**KIRKLEES METROPOLITAN COUNCIL
INVESTMENT & REGENERATION SERVICE**

DELEGATED DECISION TO DETERMINE PLANNING APPLICATIONS

| Site Address: | 103, Scholes Lane, Scholes, Cleckheaton, BD19 6LY |
| Description: | Erection of first floor side extension and single storey extension |

PROPOSED SIDE ELEVATION Scale 1:100

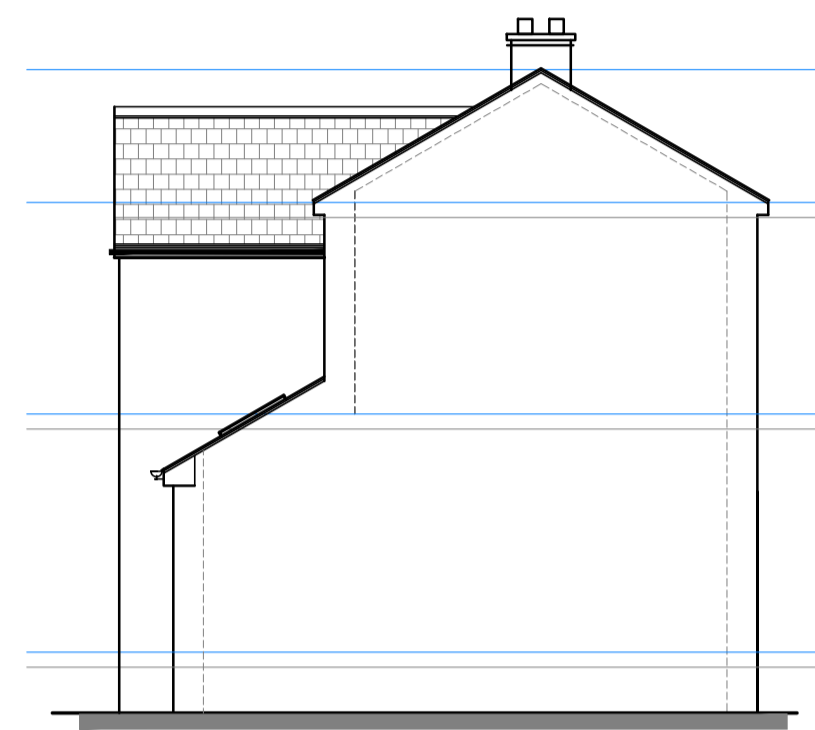
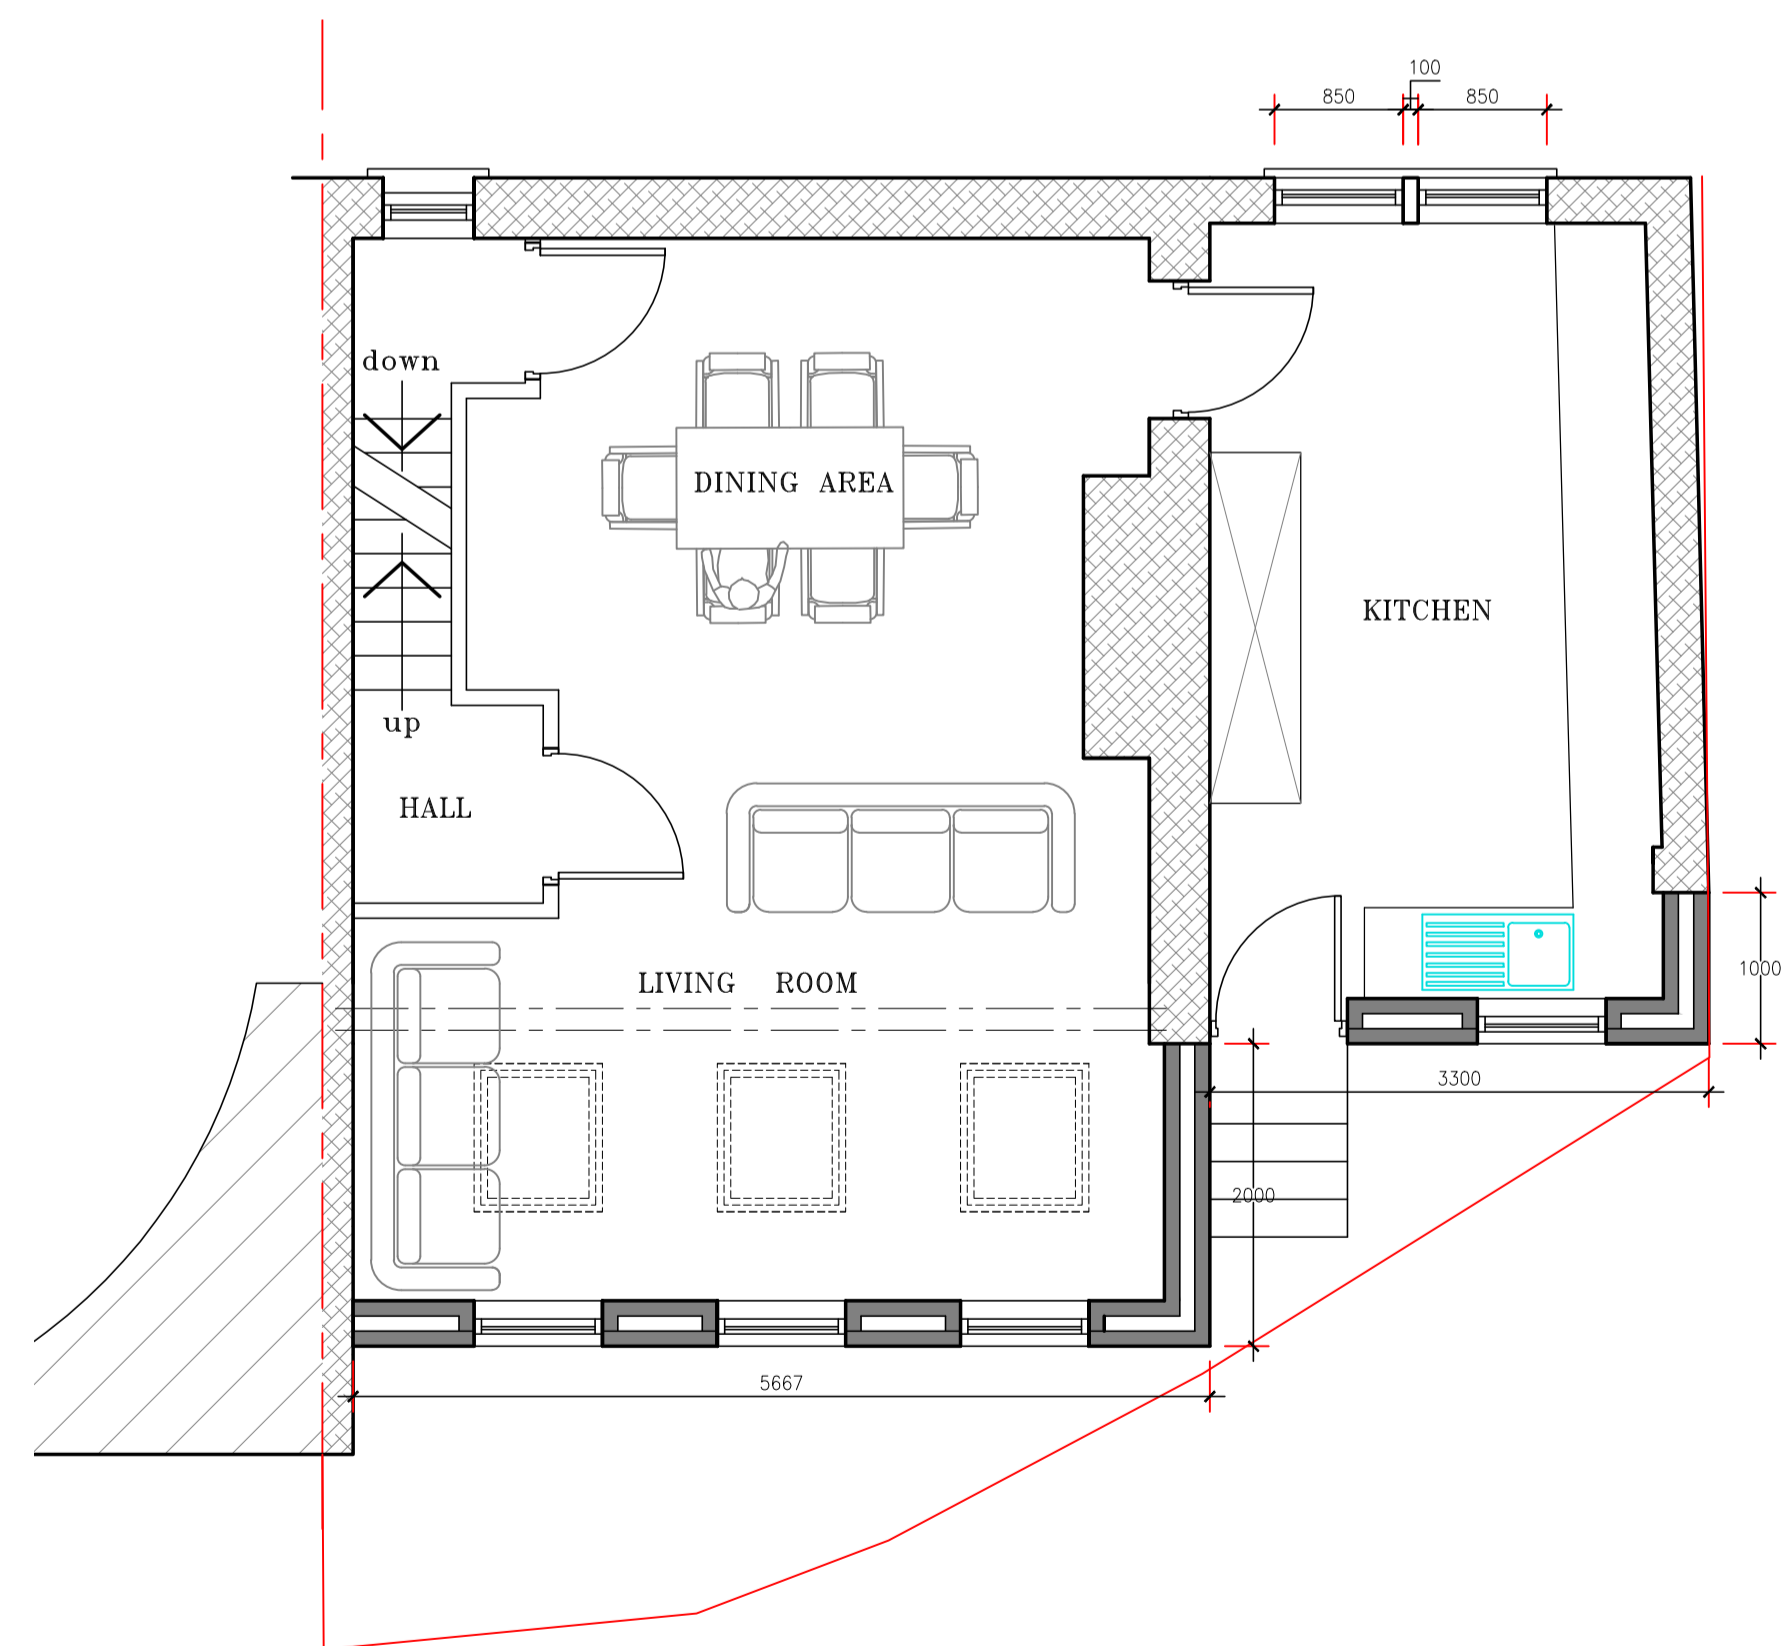
| Two Storey Side Extensions Should: | <u>Yes - COMPLY</u> | <u>No - JUSTIFY</u> |
|---|---|--|
| maintain a 1 metre gap to the side boundary to ensure the building is not too close to a neighbouring property; and | | N/A – The existing single storey section is built against the site boundary, and that the boundary is located along an access road with the closest building over 7m away to the north. Therefore the fact the proposal would be up to the boundary is not considered to have a significant impact in this case. |
| be set back at least 500mm from the front wall of the house. | | N/A – The proposal is for a first floor extension and follows the foot print of the existing single storey section. Furthermore the proposal is to an end terraced property, as such it is considered that the impact of the proposal not being set back would not |

| | | be significant in this case taking account of the orientation of the dwelling which has the main openings facing east, which is an elevation of less prominence. As such to require a set back from either the western or eastern elevation is not considered to be of any design benefit in this case given the context and circumstance of the site. |

| Height, scale and massing | <ul style="list-style-type: none"> • KDP 1 and 2 of the SPD • Policy LP24 Design (a), (c) and (d) of the KLP • Chapter 12 of the NPPF | As above. The extension would project across the side and eastern elevation of the property. The proposed development consists of a first floor extension to the side and single storey extension which respects the character of the existing dwelling. | ✓ |
| Roof style | <ul style="list-style-type: none"> • KDP 1 and 2 of the SPD • Policy LP24 Design (a), (c) and (d) of the KLP • Chapter 12 of the NPPF | Formation of gable end to the side extension, pitched lean-to roof style to the single-story extension. All roof styles are acceptable as they are in-keeping with the original roof style of the host property and/or match the character of the street scene. | ✓ |

PROPOSED GROUND FLOOR PLAN  
Scale 1:50

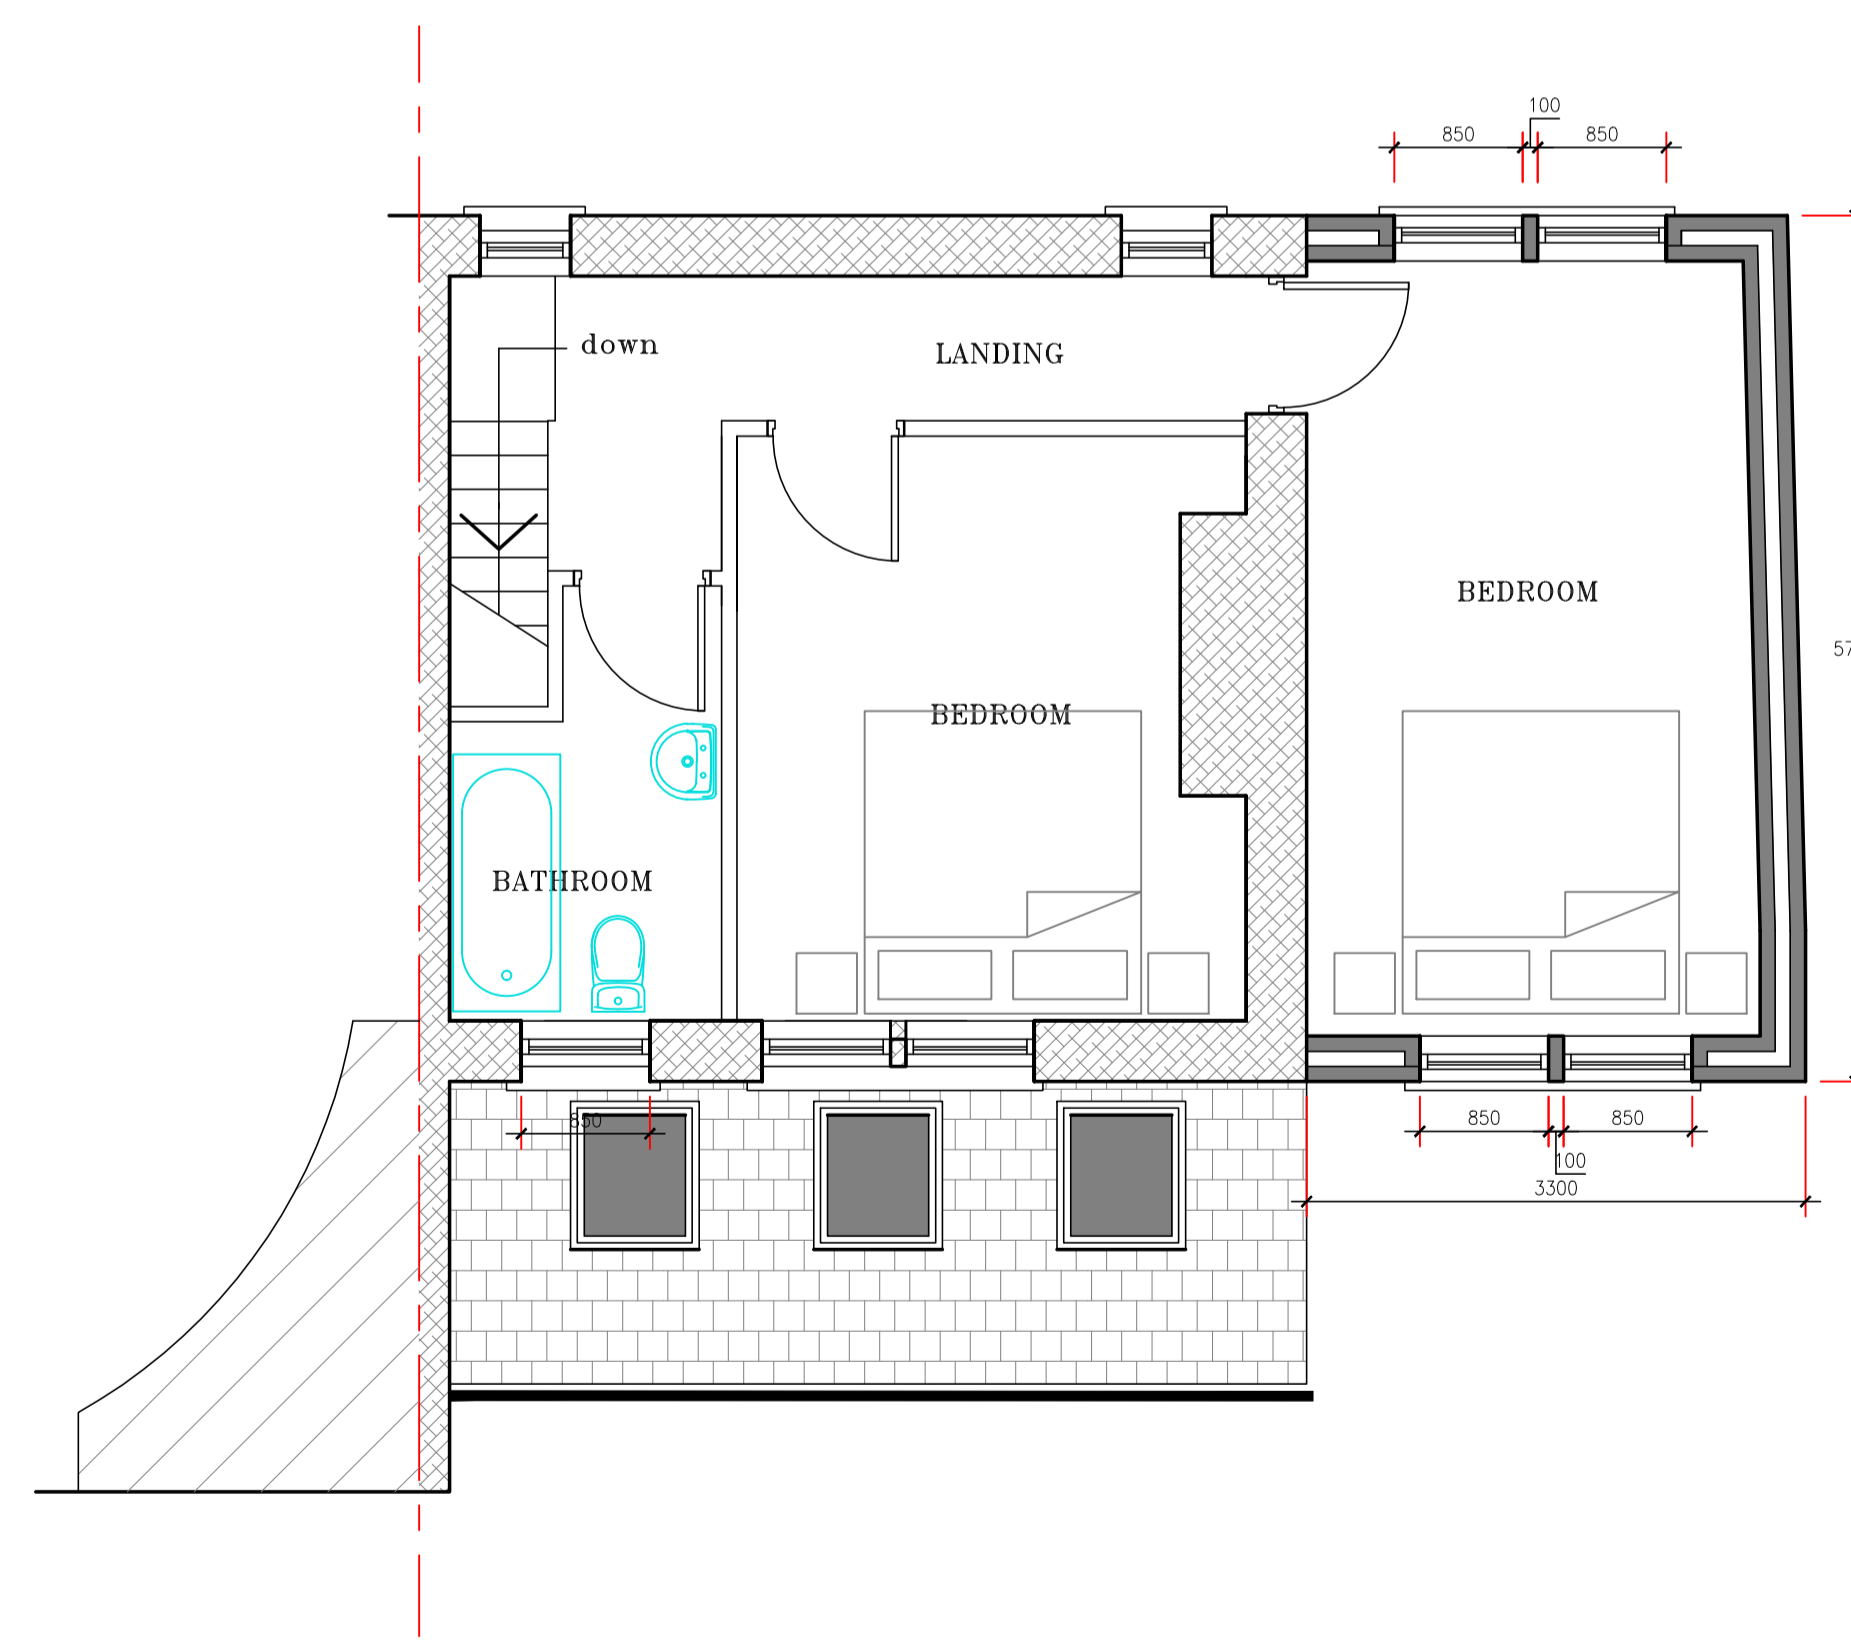
In this case the eastern elevation of the dwelling appears to form the front elevation given the development of the site originally and fact the main access runs to the east of the site. The main openings are to the eastern elevation. The Kirklees SPD sets out that single storey front extensions should comply with certain parameters set out at paragraph 5.14 on page 27 (and listed below) and if they do not, they need to be justified:

| Single storey front extensions: | <u>Yes - COMPLY</u> | <u>No - JUSTIFY</u> |
|---|--|---|
| The extension is small, subservient to the original building, well-designed and would not harm the character of the original house or the area; and | | The site is not prominent from the main adopted highway. Properties in this terraced row have been developed with extensions of a variety of type and design to the eastern elevation. The proposal would not have a significant impact in this case given the context it would be viewed within and refusal on basis of the size of the extension could not be substantiated in this case. |

- 99 Scholes Lane – located to the north of the application site. There is a 7m gap between these properties and although this property will see additional massing and bulk to the application site, it is considered that there will be no significant impact on this dwelling.
- 101 Scholes Lane – adjoining property to the south. There will be no impact on this dwelling as the single storey extension replaces the existing porch and does not extend beyond the eastern elevation building line of no.101.
